Submission in relation to State Significant Development Application Number SSD-82900461; 11-19 Middle Harbour Road, Lindfield

Figure 2 Proposed Height Banket Diagram.

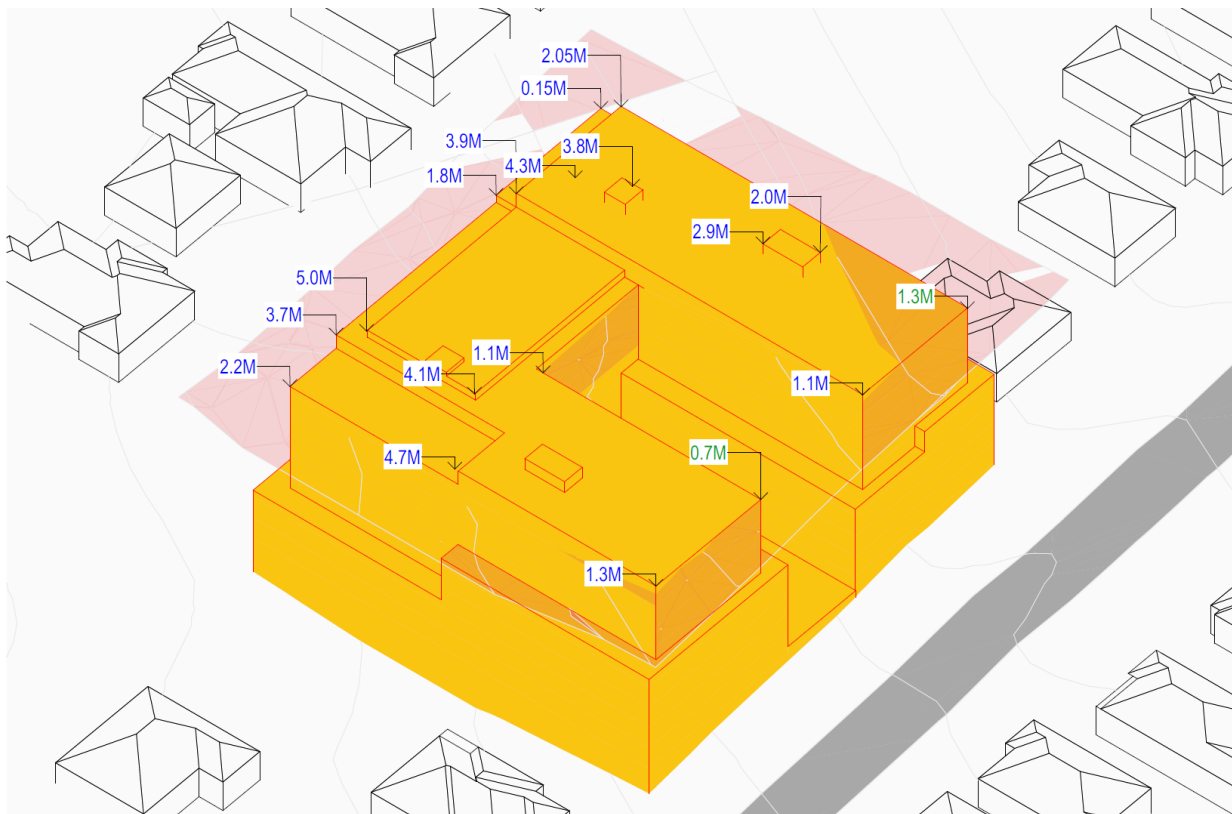
Accordingly, the first objection to the development is the sheer bulk and size of the development, which far exceeds reasonableness for the site area, the site topography and the site location, including the fact that it proposes a built height that exceeds the maximum permissible height under current TOD planning regulations (28.6 metres) by approximately 5 metres and the proposed maximum height under the Ku-ring-gai Preferred Alternative Planning Scheme of 18.5 metres. Given the elevation of the development site over the properties to the east of the development site this is a significant and unwarranted height exceedance. There is no merit in the argument that the built height needs to exceed the already generous maximum height permissible of 28.6 metres under the current TOD particularly where the Ku-ring-gai

<i>locality to see a six (6) storey residential flat building adjoining a single storey dwelling house.</i>	
33	<i>Visual Impact: The proposal provides a bulk and scale of development which is anticipated by the applicable built form controls under the Housing SEPP. Whilst the proposal will increase the scale of the development on the site, the visual bulk of the development will be mitigated by the design and siting of built form in the Detailed SSDA. When viewed from the streetscape, the cumulative impact of the development on the streetscape is to be reasonably anticipated, particularly as a result of the provision of a street podium level which creates a human scaled design element at the street frontages.</i>	The design and siting of the development with a nine storey building that exceeds the permitted height by 5 metres and which has 6 metre set backs from the boundary cannot be said to mitigate the monolithic bulk and scale of the proposed development.

33-34	Section entitled “Alternative Development Option”	The alternative development option that will be provided by the Ku-ring-gai Preferred Alternative Planning Scheme (which is highly likely to be approved by the State Government as it meets the required housing targets) of five storey residential flat buildings with a maximum height of 18.5 metres has not been mentioned in the EIS, which is a catastrophic failure of the author and one that a professional planner should at least have made mention of.
37	<i>As detailed the proposal seeks consent for a Concept SSDA to establish the building envelope for the site. The proposed built form has been carefully considered and designed to ensure its responds to the existing low density residential context of the locality whilst achieving the permitted bulk and scale in accordance with the new Housing SEPP initiatives. The proposed form has been designed to reduce the visual bulk of the development where possible to minimise the adverse impacts which inevitably result from increased density.</i>	It is difficult to see how the proposed design form could have been any more visually bulky with a height exceedance of 5 metres and only 6 metre set backs from the boundary.

NORTH ELEVATION
1:200

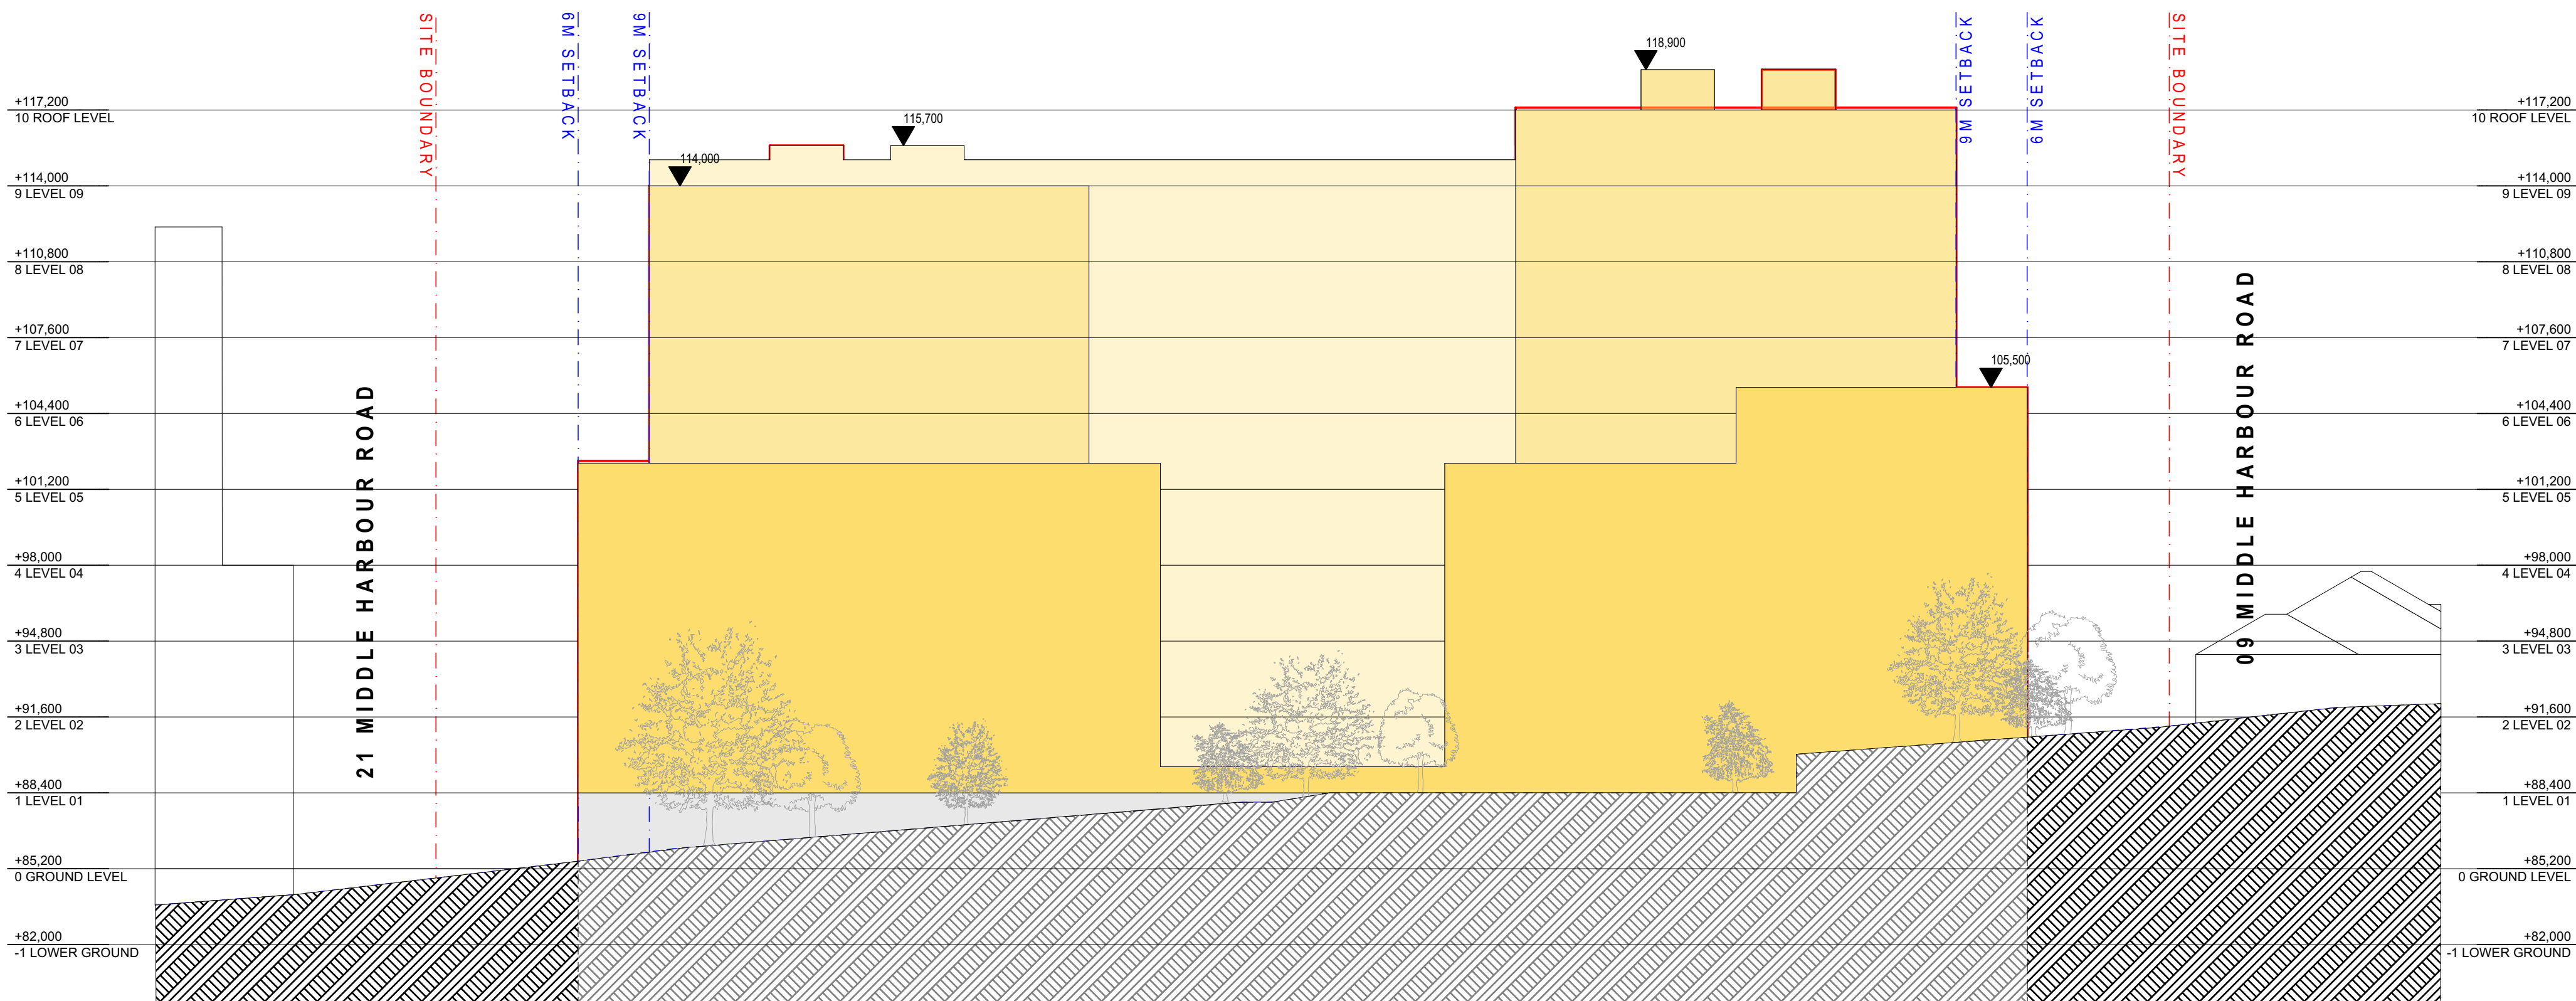
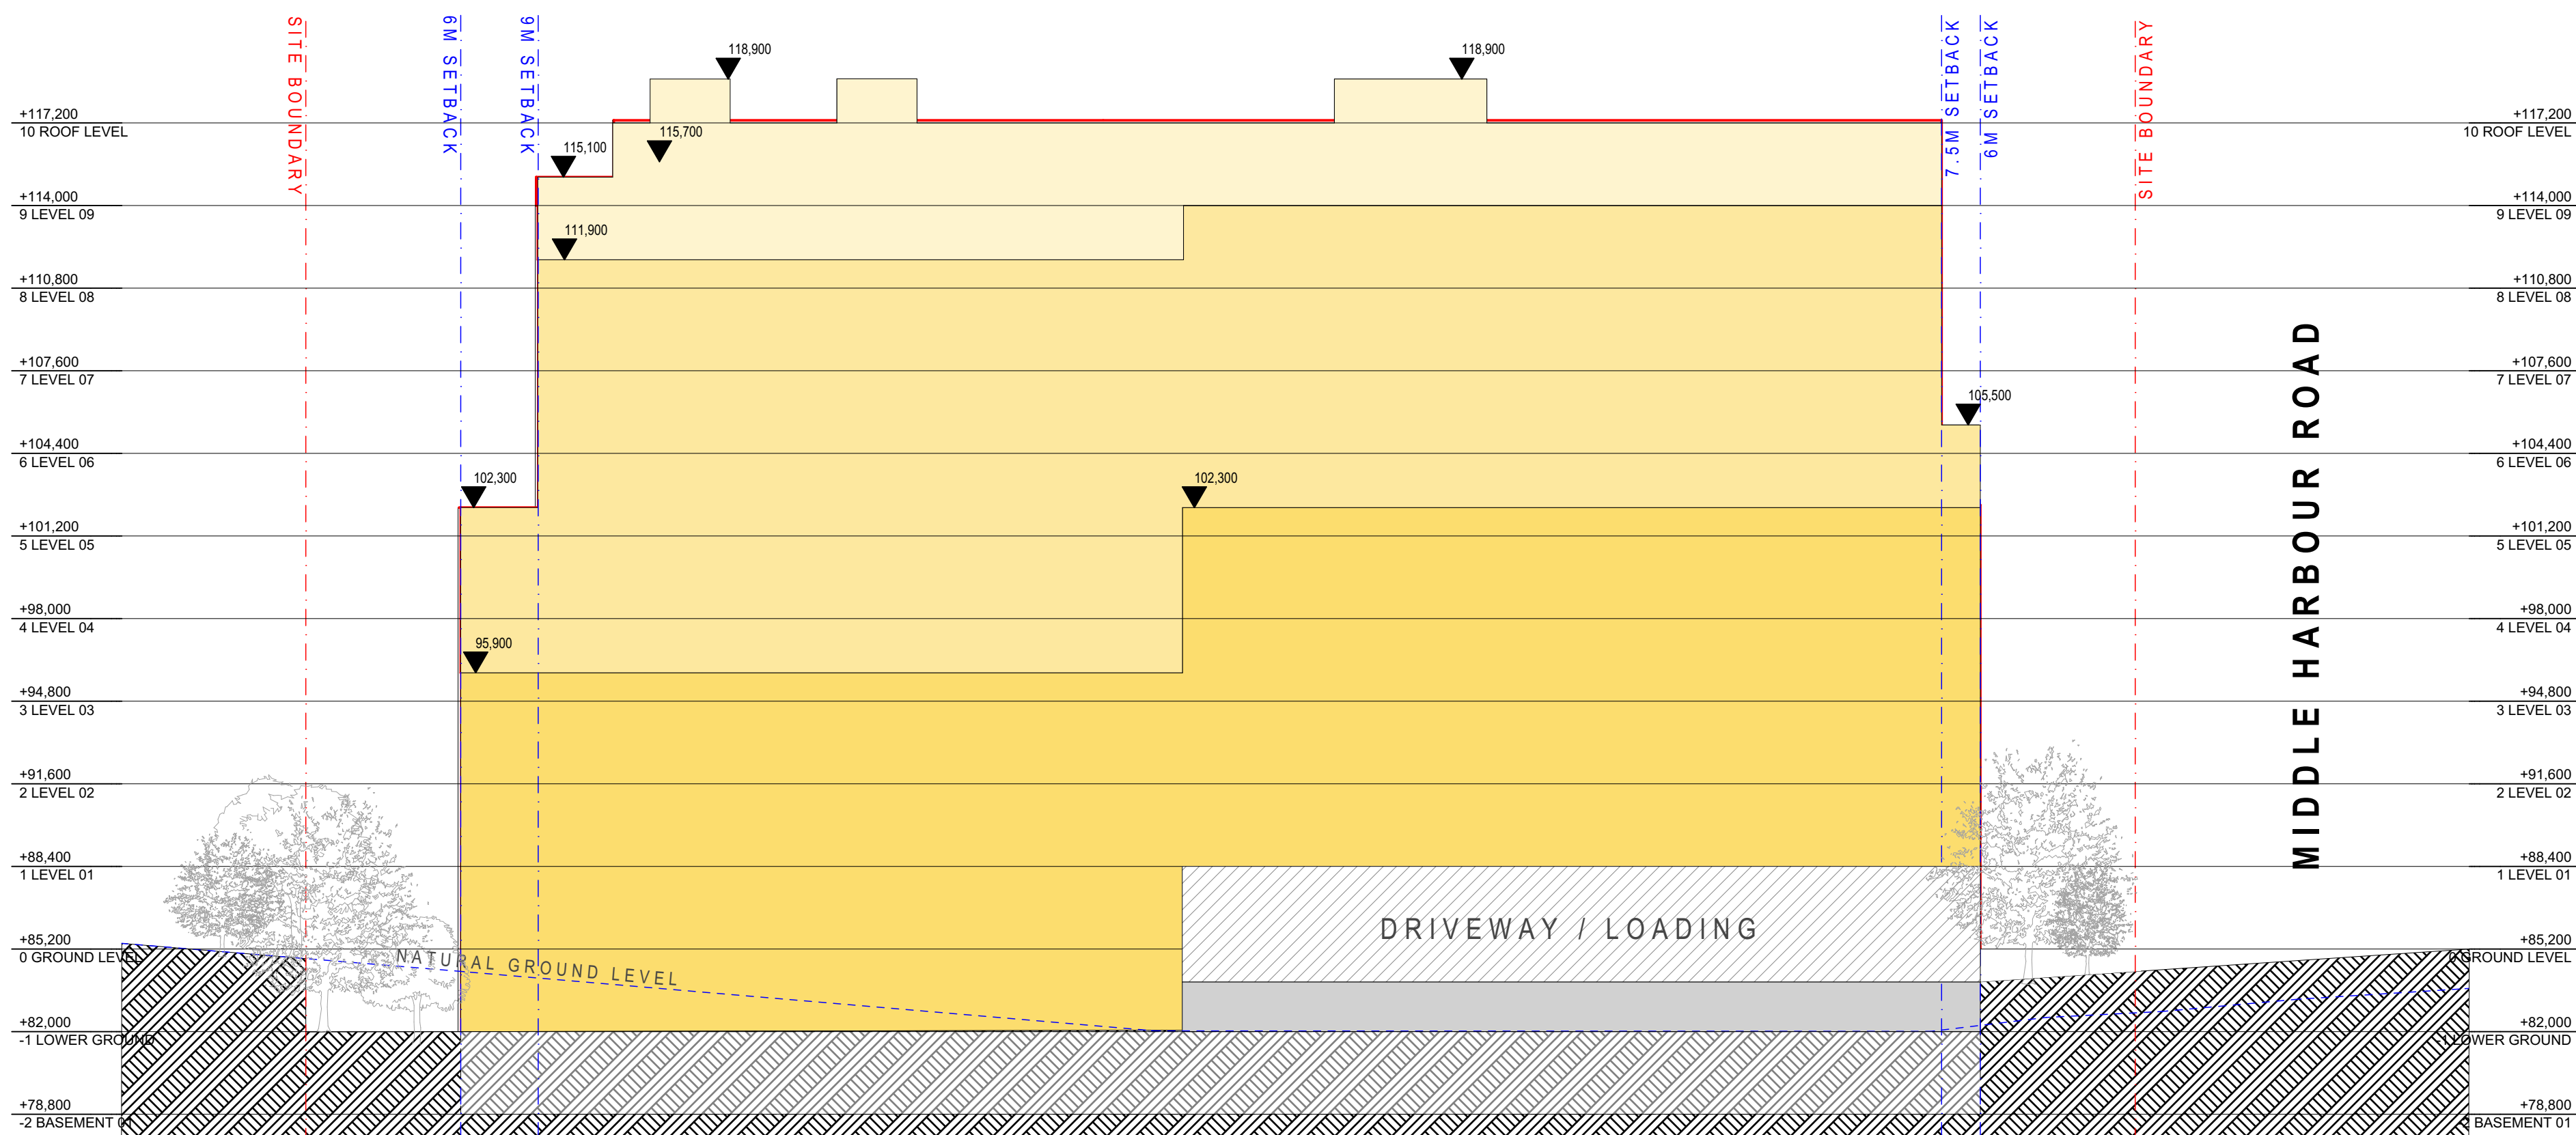
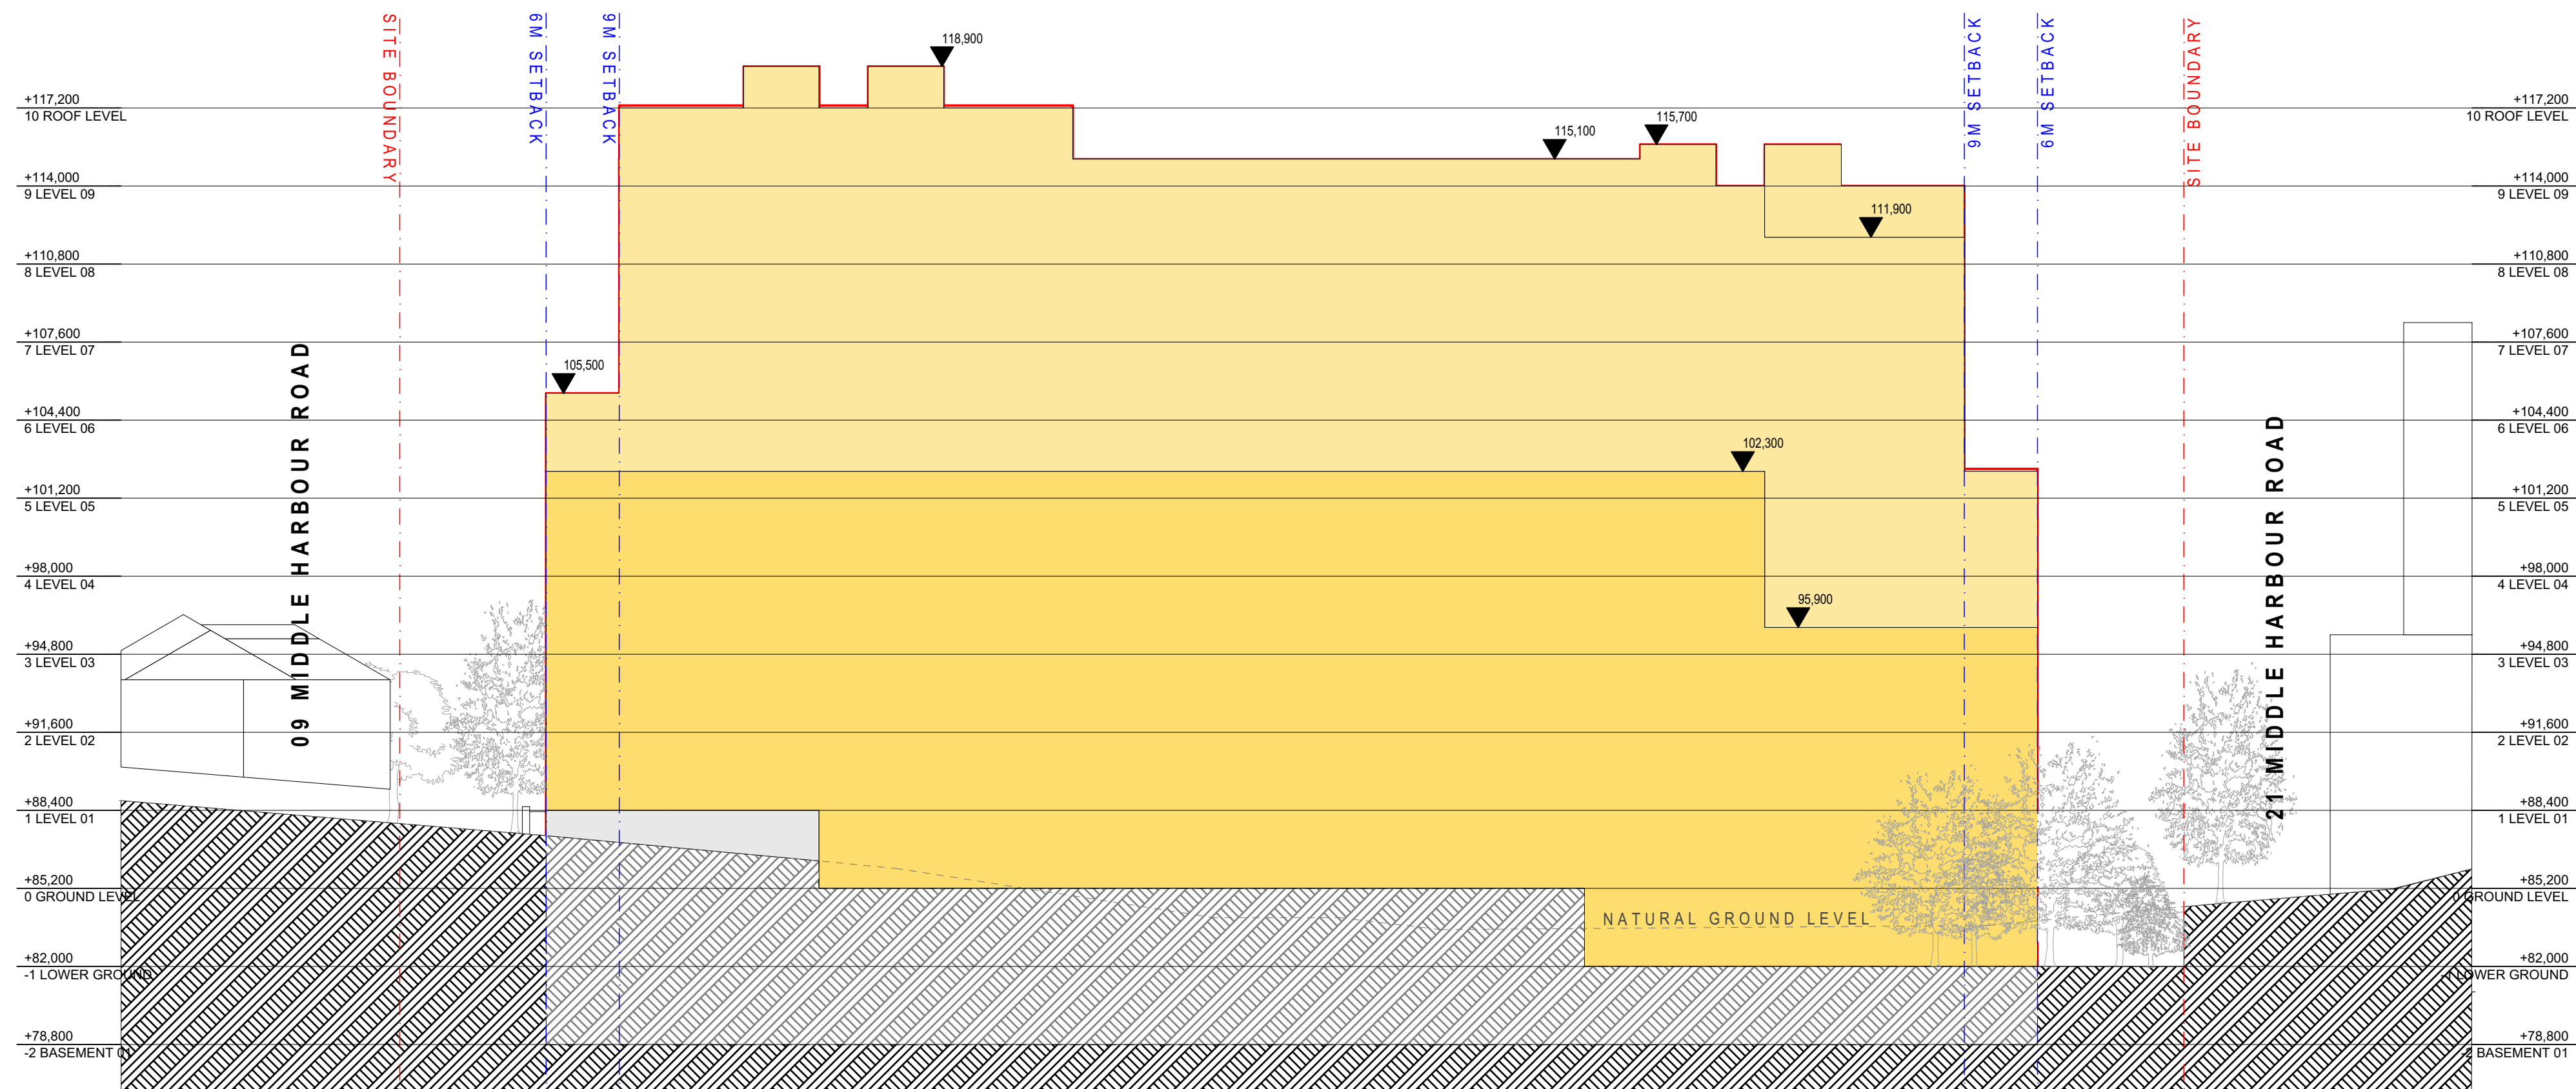
The eighth objection is to the loss of solar access and privacy for surrounding homes that the development will cause. A development in excess of 33 metres in height will have a detrimental affect on many neighbouring properties in terms of:

- (a) the overshadowing of houses to the east and west of the development site and the resultant loss of solar access, exacerbated for those properties to the east by reason of the elevated site location vis a vis the properties located to the east; and
- (b) the loss of privacy of the residences in the vicinity of the development, with floors 2 to 9 looking down on the surrounding properties, including their pools, backyards and outdoor entertaining areas.
